<b>Application Reference Number:</b>	2026/0266.
--------------------------------------	------------

<b>Application Type:</b>	<i>Prior Notification – Class MA – commercial, business and service uses to dwellinghouses.</i>
--------------------------	---

<b>Proposal Description:</b>	<i>Application to determine if prior approval is required for the change of use of an office building (Use Class E(g)(i)) to 9 apartments (Use Class C3) via Schedule 2, Part 3, Class MA.</i>
<b>Location:</b>	<i>23 Queens Road, Barnsley, S71 1AN.</i>

Drawing title:
Proposed 1F Plan

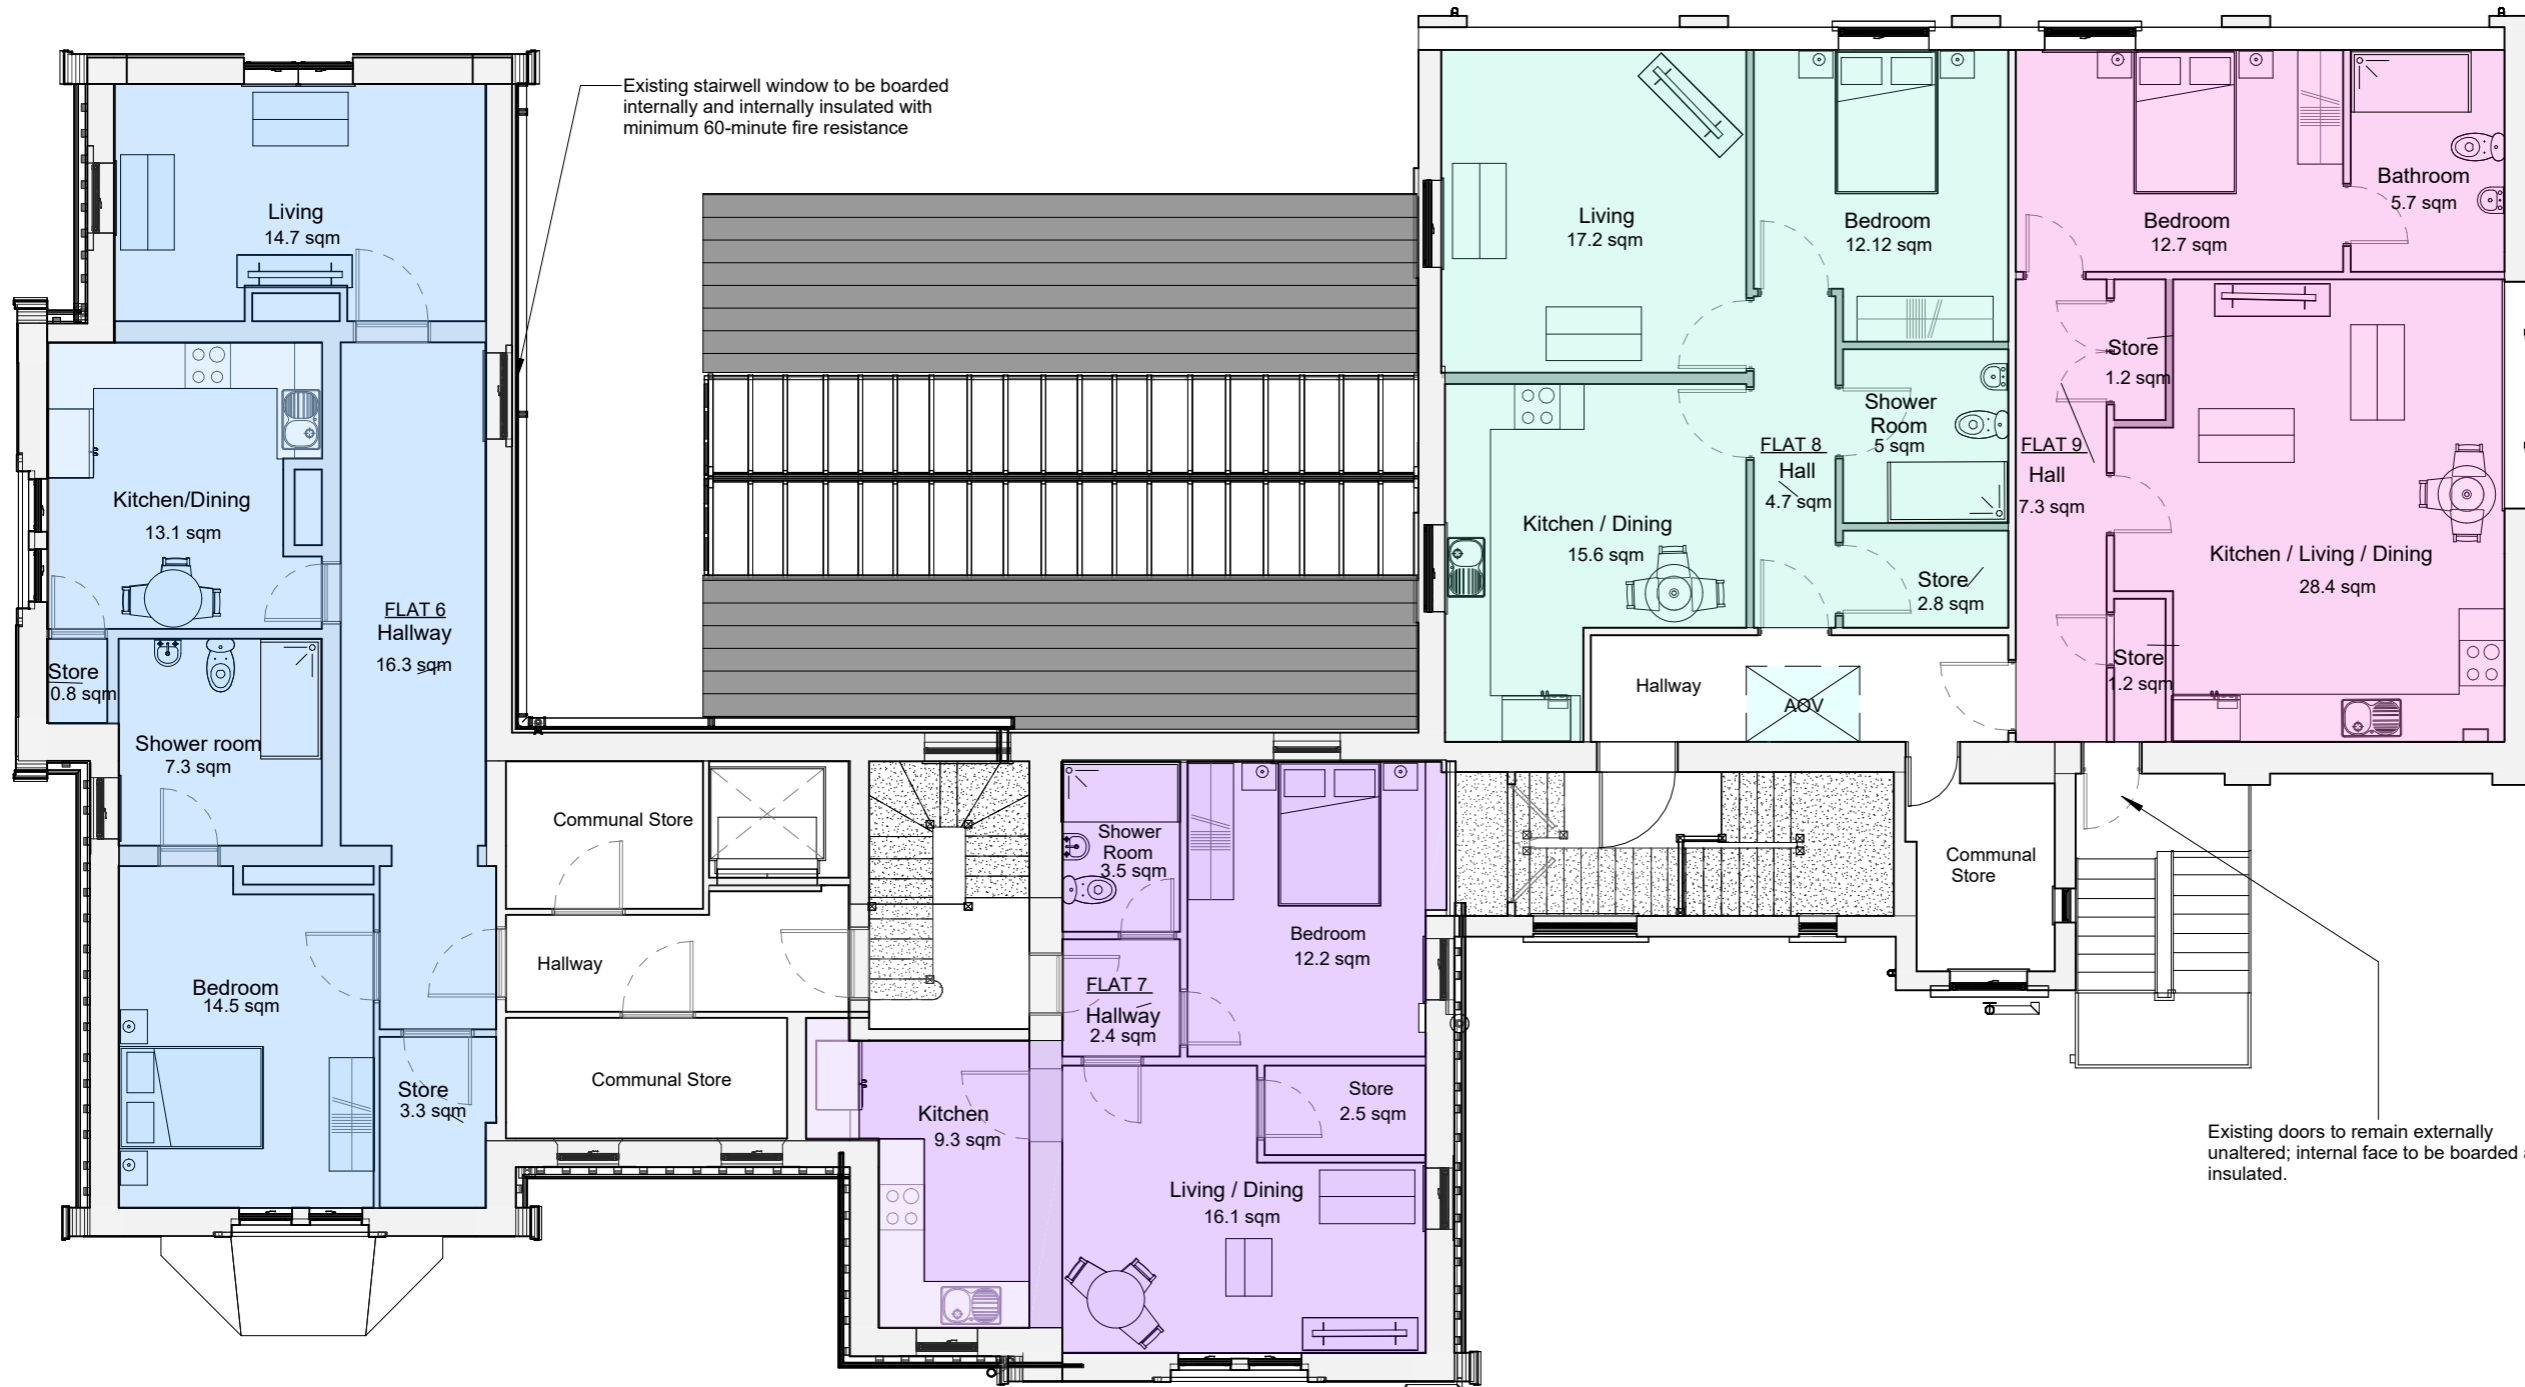
The proposal would provide windows or rooflights to all habitable rooms as indicated on the submitted drawings 2026-2190 08 Rev. A; 2026-2190 09 Rev. A; 2026-2190 10; 2026-2190 11; and 2026-2190 12 Rev. A.

The submitted plans 2026-2190 08 Rev. A and 2026-2190 09 Rev. A demonstrates that all apartments appear to comply with the Nationally Described Space Standard (NDSS) technical requirements. The overall floorspace of apartments 1,2 and 7 are sufficient for one person. All other apartments are sufficient for two people.

PROPOSED GROUND FLOOR PLAN

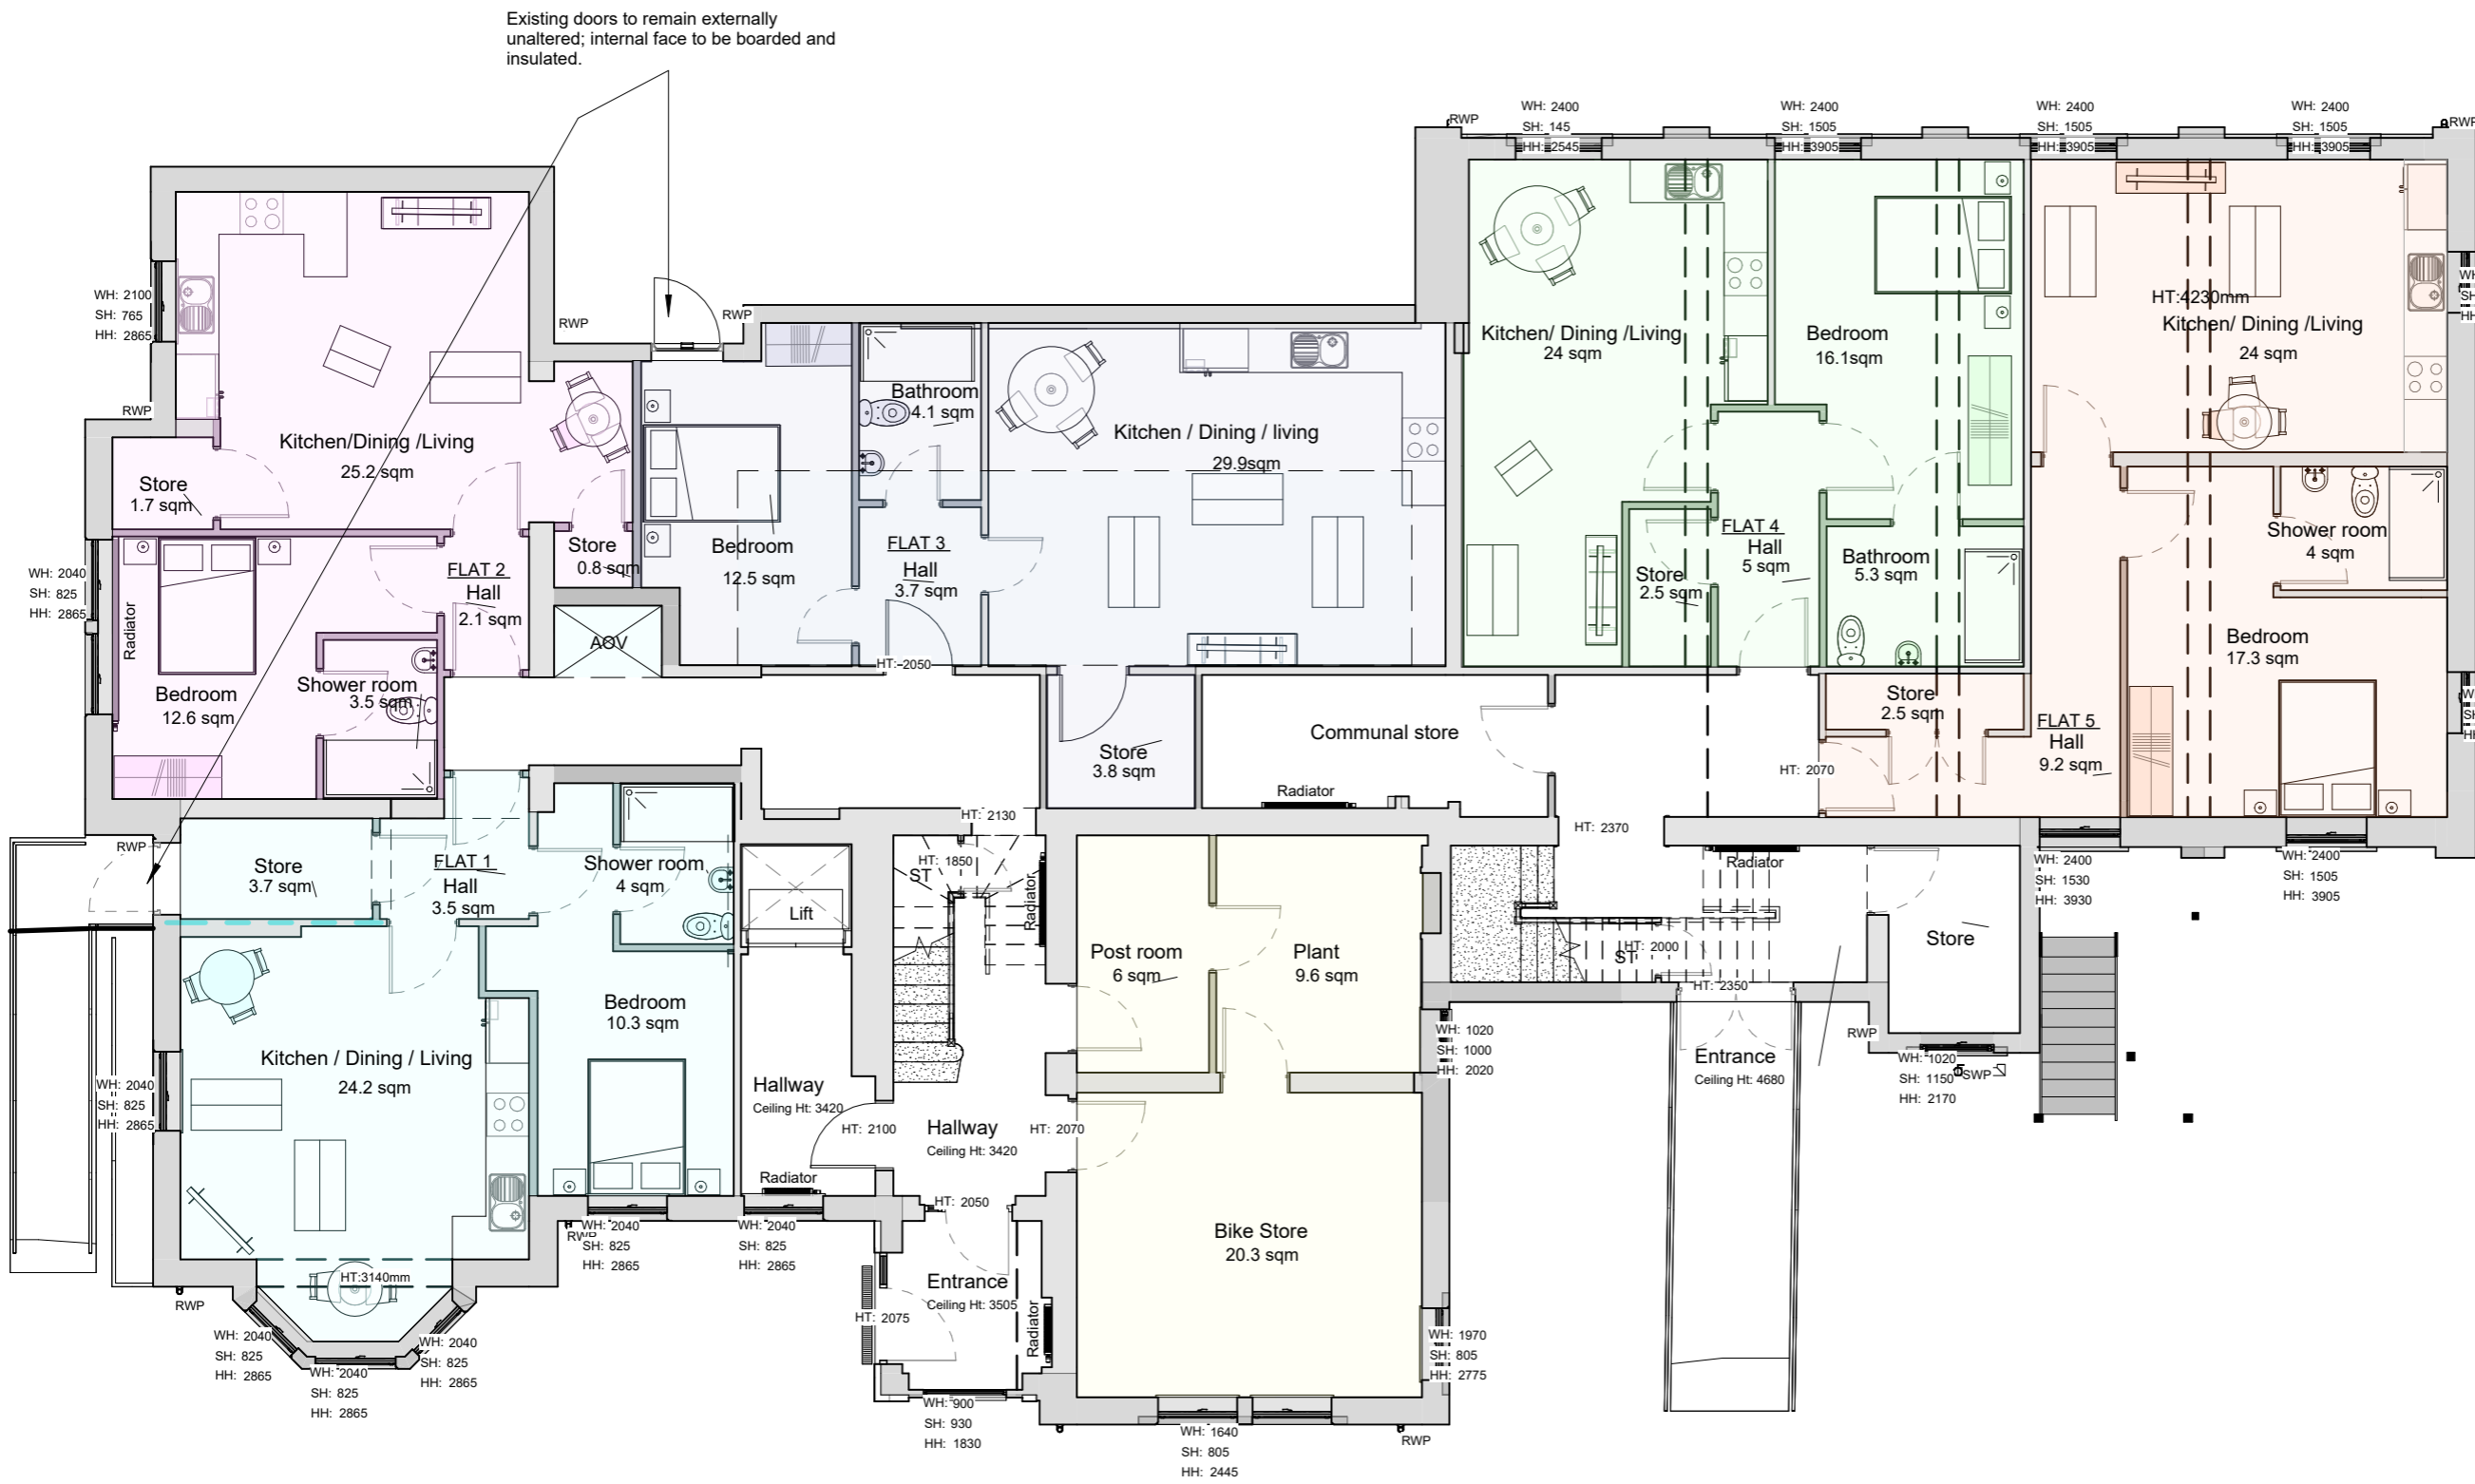
location was noted. It was also stated that proposed cycle store shown on the proposed ground floor plan (2026-2190 08 Rev. A) would be of a sufficient size to accommodate at least one cycle parking space per apartment in accordance with national and local planning policies and guidance. As such, Highways Development Control colleagues raised no objections subject to a condition to secure a scheme for the storage of bicycles as shown on the submitted plans.

5. Prior to occupation, the scheme for the storage of bicycles as shown on the submitted plans [2026-2190 08 Rev. A] shall be fully implemented and retained thereafter.
